# **Awel y Môr Offshore Wind Farm Examination Review of SLVIA Documents**

**Final report**  
Prepared by LUC  
October 2022

### Awel y Môr Offshore Wind Farm Examination Review of SLVIA Documents

This image provides landscape and visual context only

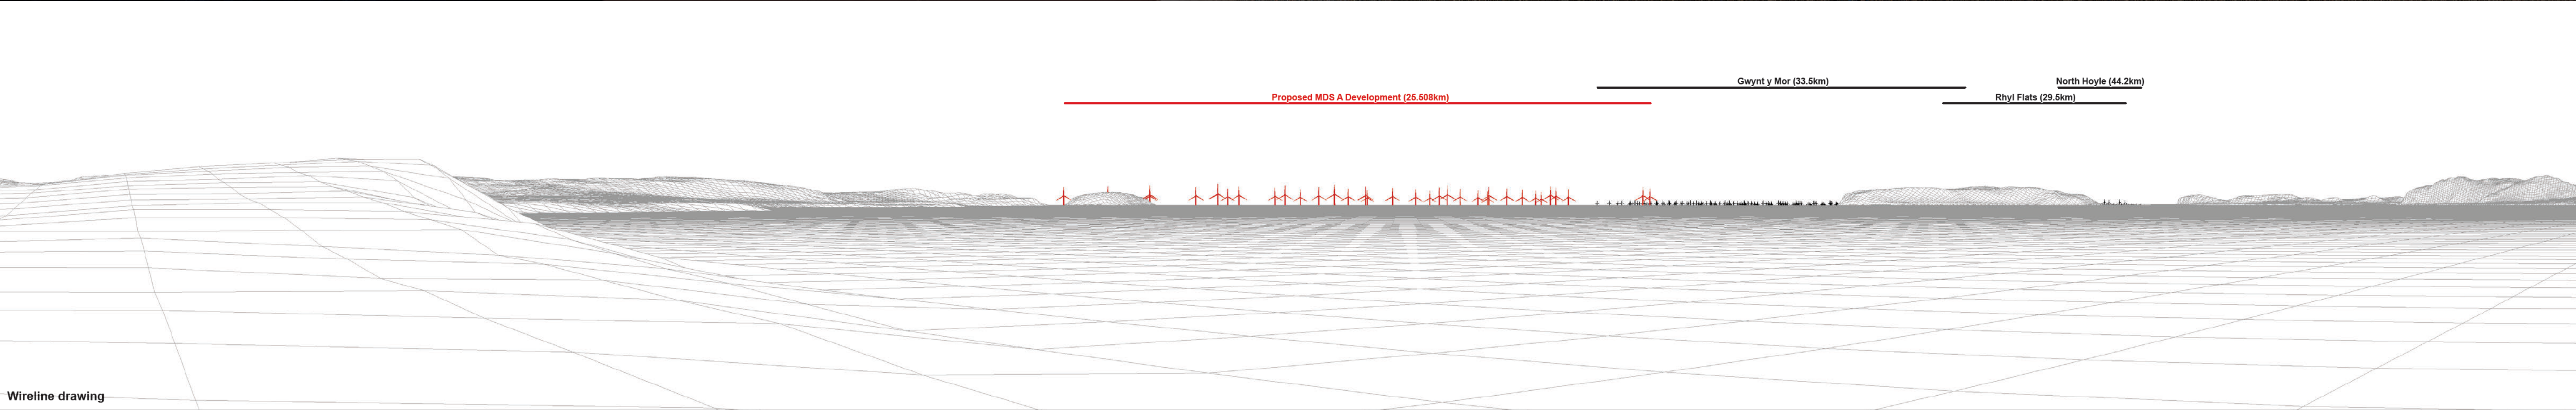
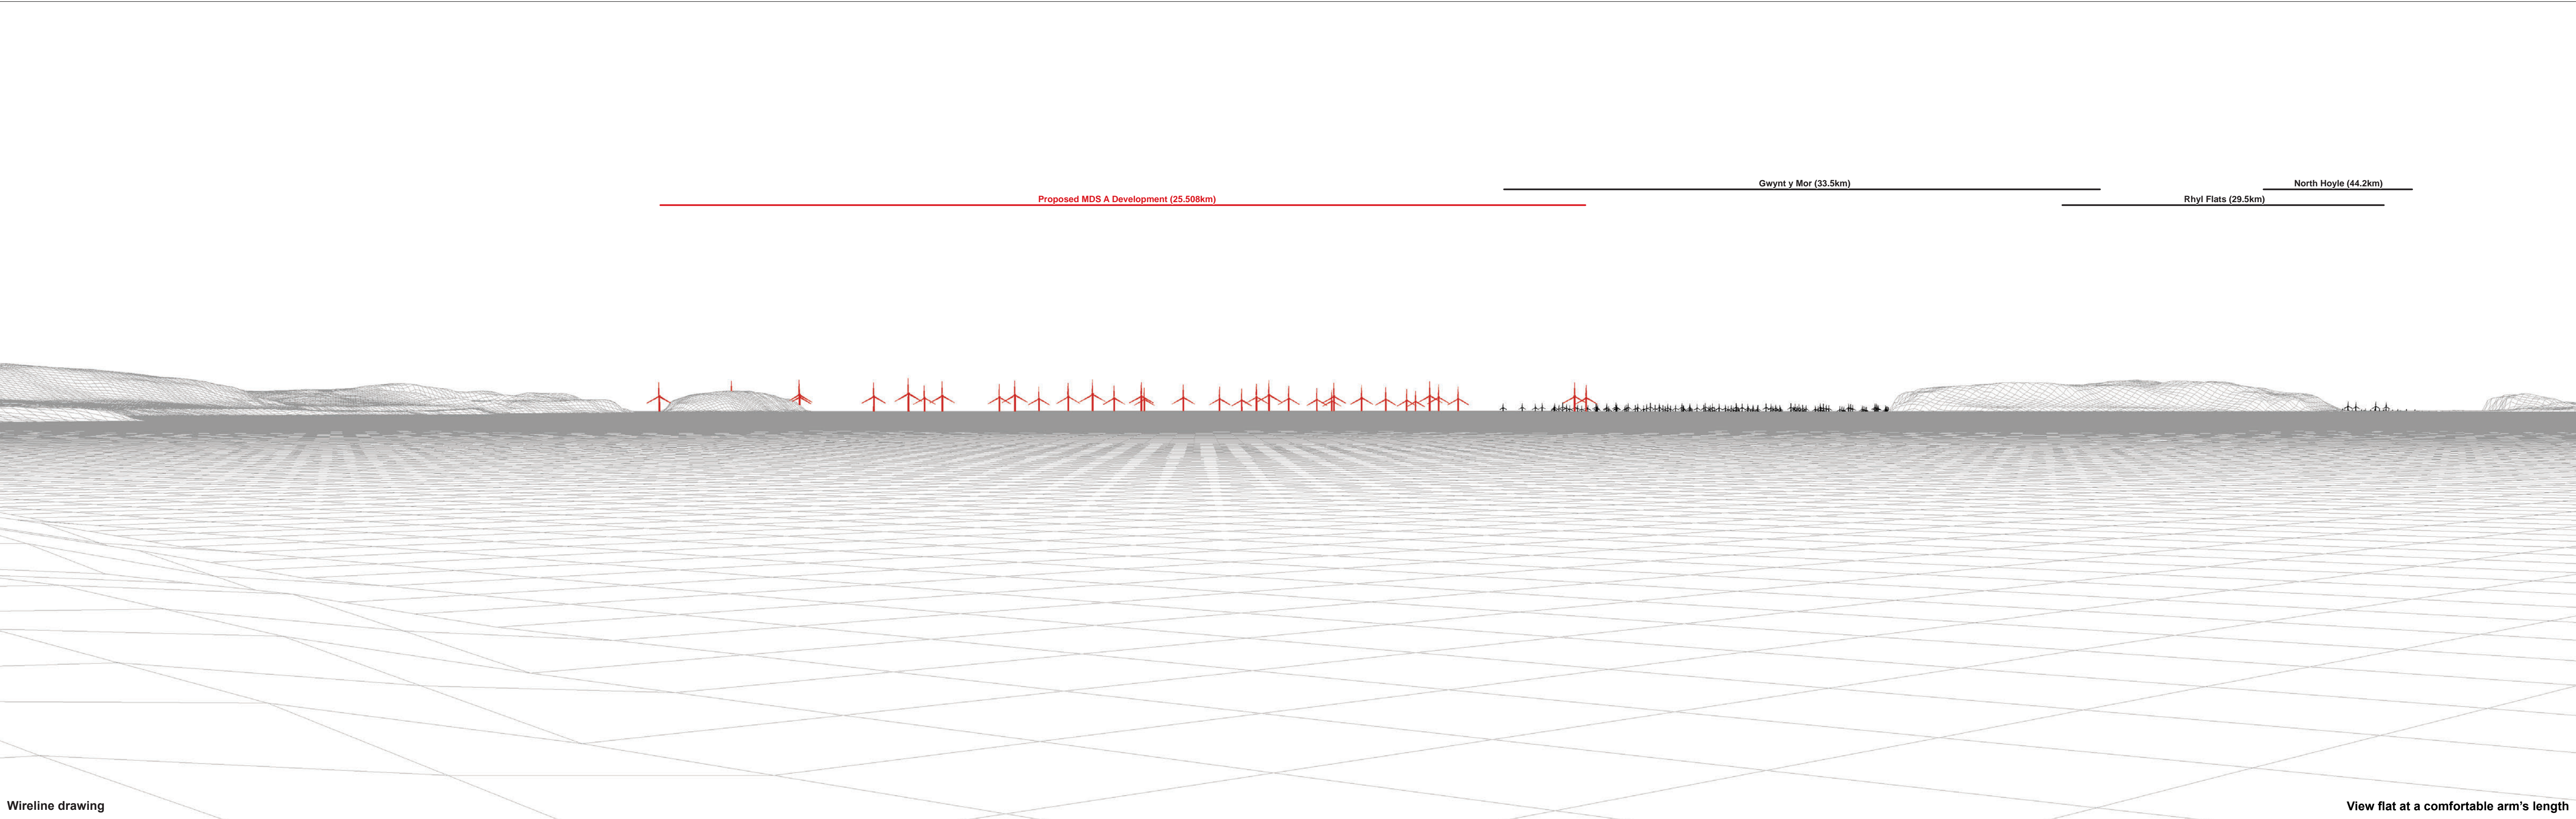
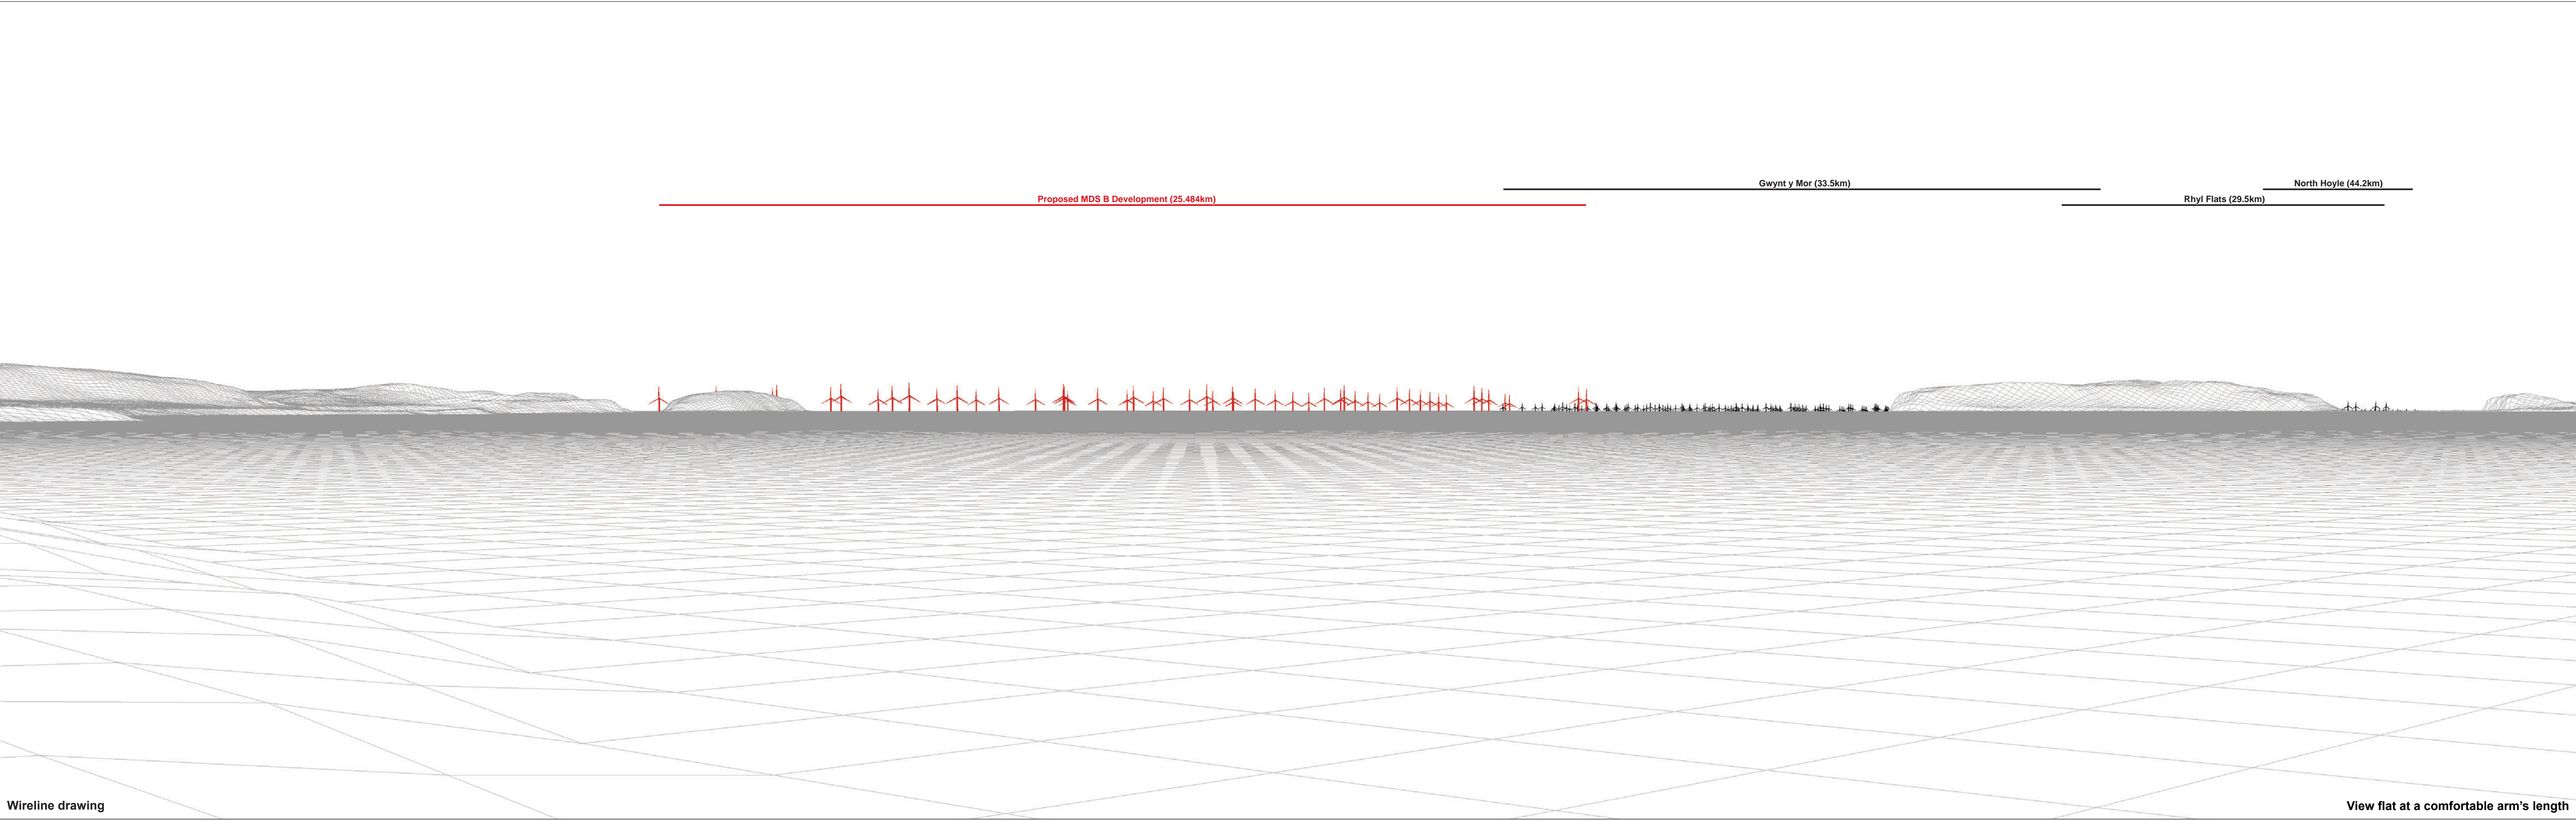
**3.9** There are 13 assessment viewpoints on Anglesey, and the SLVIA finds significant effects at eight of these locations. This is the same result as in the PEIR. All the identified significant effects are 'moderate', with the exception of VP7 Penmon Point and VP8 Beaumaris, which are 'major-moderate'. These findings are agreed.
